**EL PASO COUNTY**

**Subject: Forest Lakes Filing No. 6 Final Plat, Preliminary Comments (SF-20-027)**

### Forest Lakes Filing No. 6 Final Plat Development Application Review

FOREST LAKES FILING NO. 6

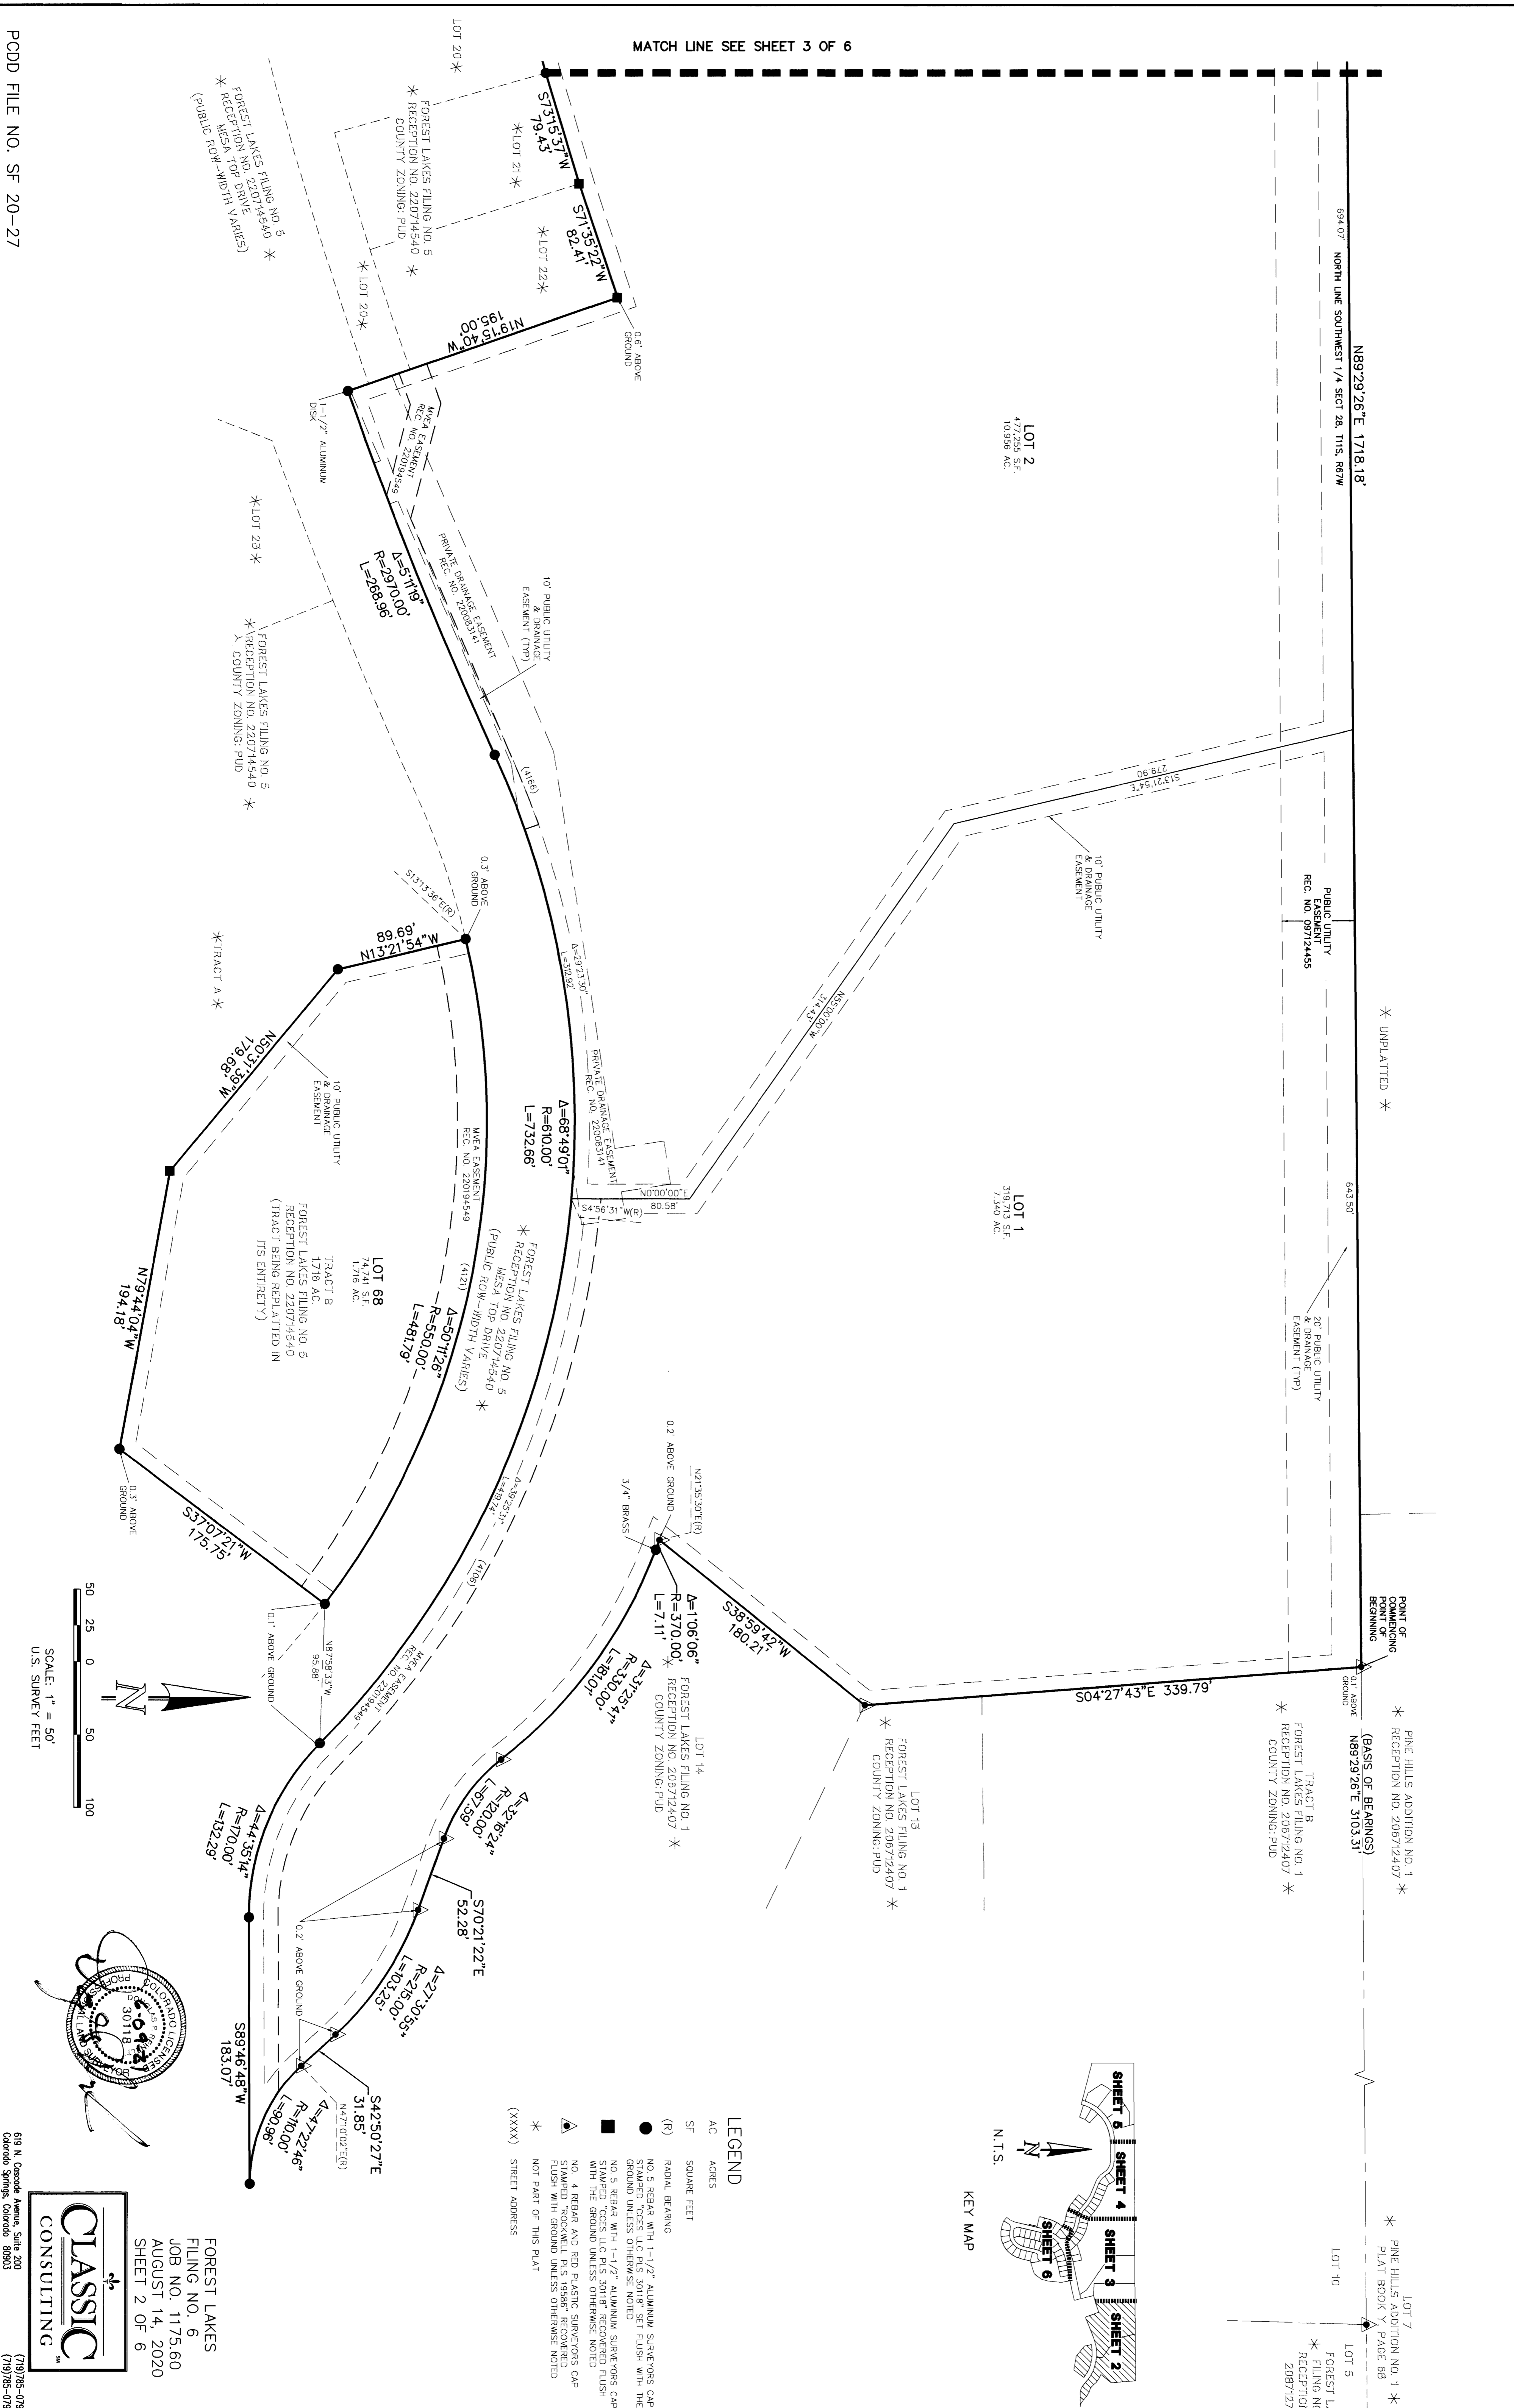
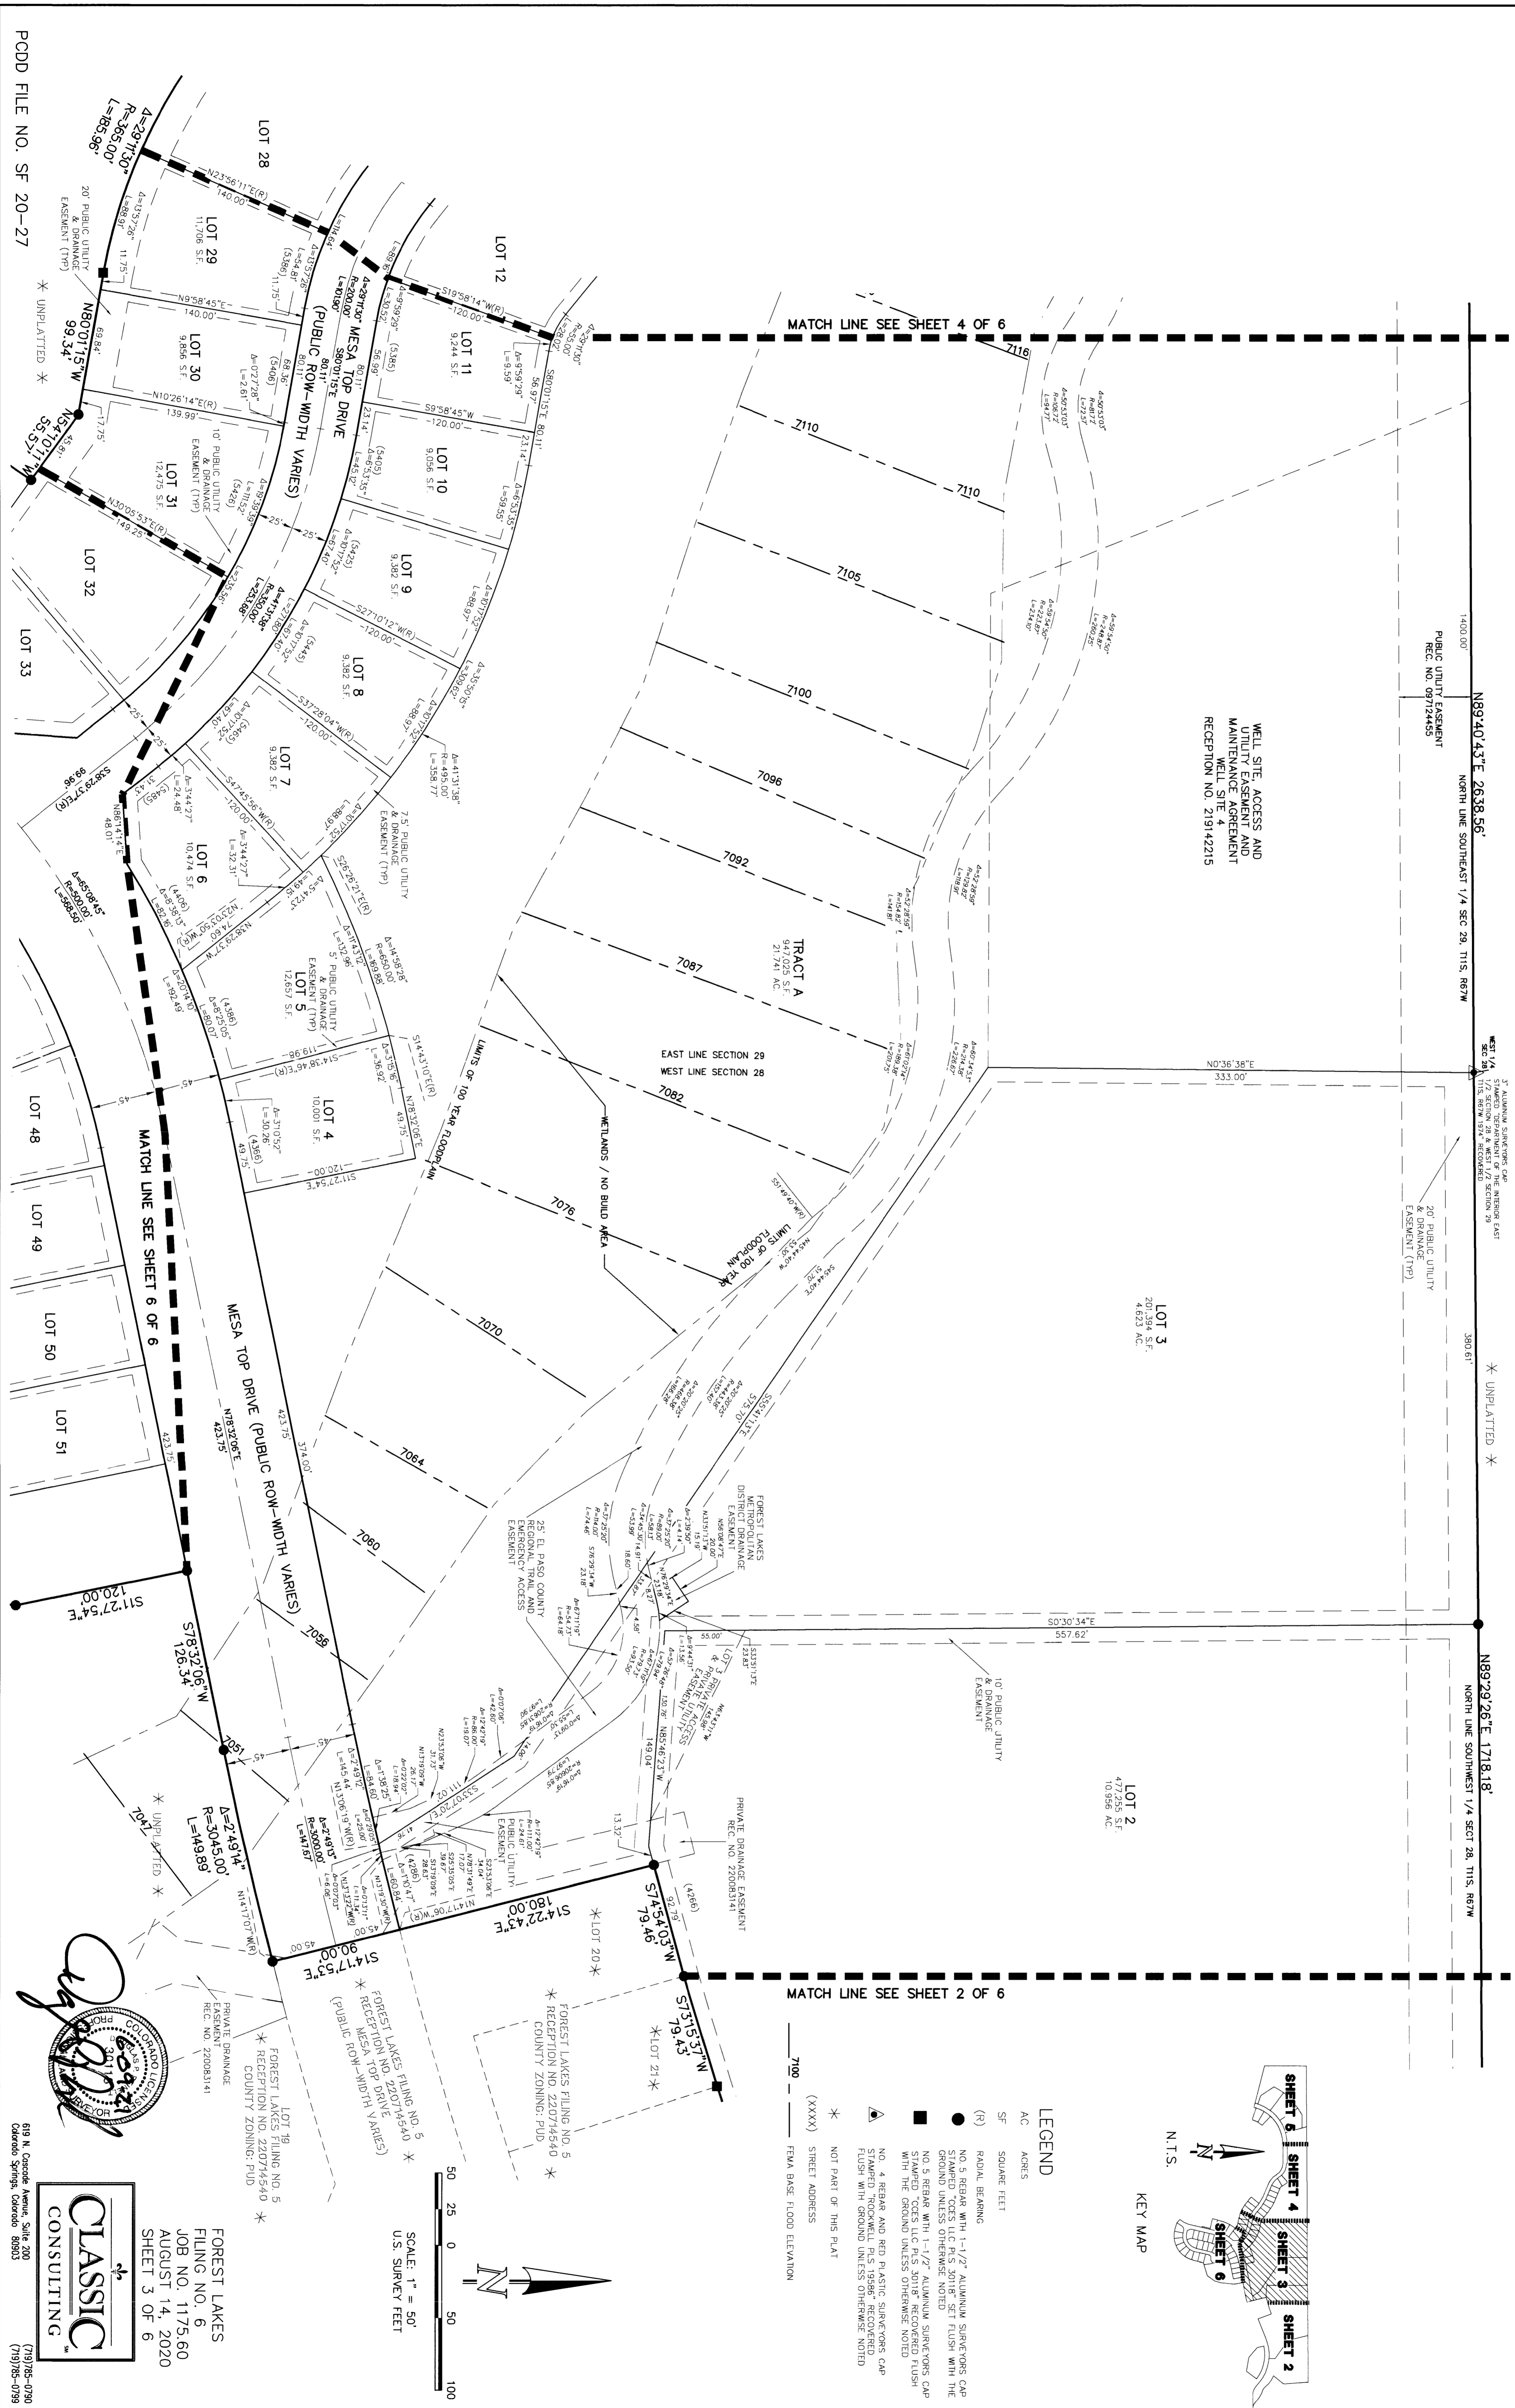
The BoCC-approved Forest Lakes Phase II PUD Preliminary Plan shows in detail the Forest Lakes Secondary Regional Trail, as well as the internal trail network and emergency access road. However, the Forest Lakes Filing No. 6 Final Plat does not show the 25-foot trail easement through the project site, and the Final Plat notes do not reference the dedication of the trail easement to El Paso County. As such, staff recommends that the applicant include the easement alignment in the Final Plat drawings and include language in the Final Plat General Notes that designates and provides to El Paso County a 25-foot trail easement through Forest Lakes Filing No. 6, within Tracts A and B, that allows for public access of the Forest Lakes Secondary Regional Trail, and dedicate the aforementioned easement to El Paso County prior to the recording of the Final Plat.

*The Park Advisory Board recommends that the Planning Commission and the Board of County Commissioners include the following conditions when considering and/or approving the Forest Lakes Filing No. 6 Final Plat: (1) designate and provide to El Paso County a 25-foot trail easement through Forest Lakes Filing No. 6 Final Plat, within Tracts A and B, that allows for public access of the Forest Lakes Secondary Regional Trail, and dedicate the easement to El Paso County within the Final Plat General Notes prior to the recording of the Final Plat; (2) regional park fees are not required pursuant to the existing Forest Lakes Phase I PUD Preliminary Plan and Filing No. 1 Final Plat recommended and endorsed motions; (3) the section of the Forest Lakes Secondary Regional Trail located within Filing No. 6 shall be constructed within two years of the recording of the Final Plat; (4) trail plans shall be submitted to and approved by County Parks prior to construction; (5) the trail shall be constructed to Tier 1 standards for a regional trail; (6) the trail shall be maintained by the Forest Lakes Metropolitan District when contained within developer-owned tracts, while El Paso County agrees to maintain the Regional Trail when contained within dedicated roadway rights-of-way; (7) require fees in lieu of land dedication for urban park purposes in the amount of \$20,060. A Park Lands Agreement may be an acceptable alternative to urban park fees, provided the agreement is approved by the County and executed prior to recording the Final Plat.*
